From: Tom Errico <thomas.errico@tylin.com>
To: David Margolis-Pineo <DMP@portlandmaine.gov>
CC: Jean Fraser <JF@portlandmaine.gov>
Date: 7/30/2015 1:18 PM
Subject: RE: 81 Industrial Way

From: David Margolis-Pineo [mailto:DMP@portlandmaine.gov]
Sent: Thursday, July 30, 2015 11:16 AM
To: Tom Errico
Cc: Jean Fraser
Subject: 81 Industrial Way

SHEET 3 OF 7

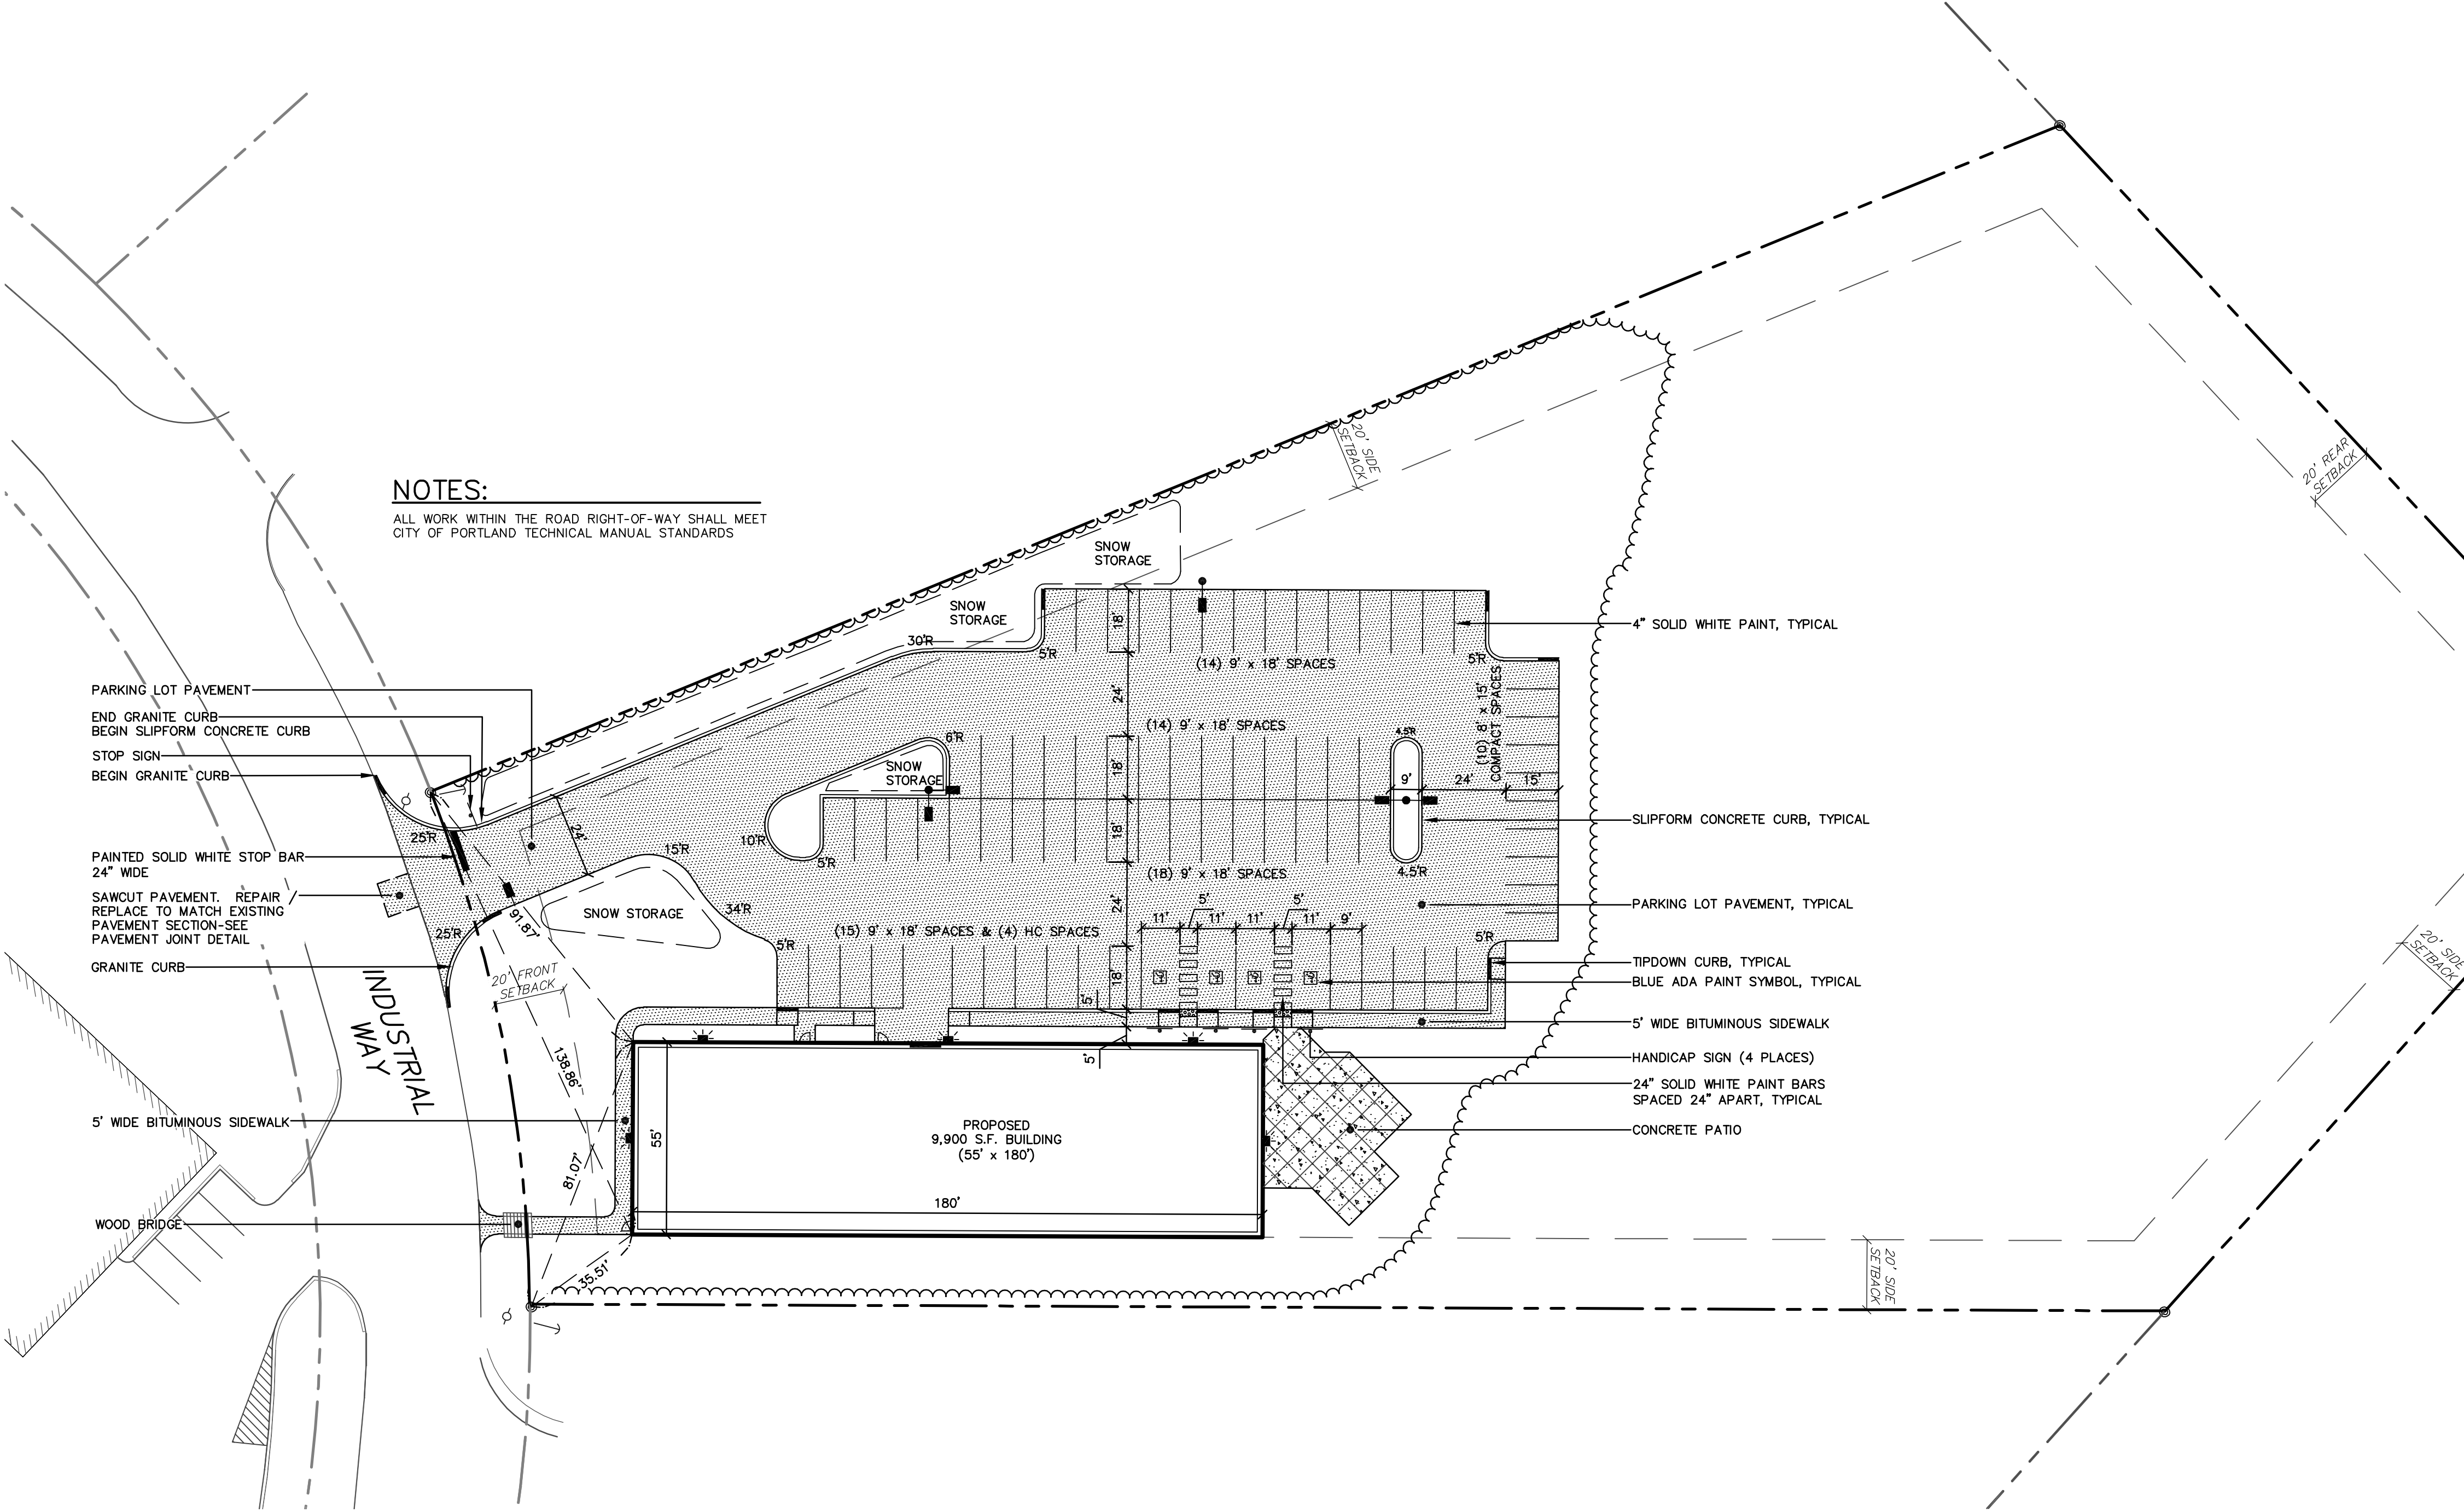
I'm not seeing the crosswalk. You got that covered?

We are not requiring a formal painted sidewalk. Only facilities that allow people to walk between the two sites
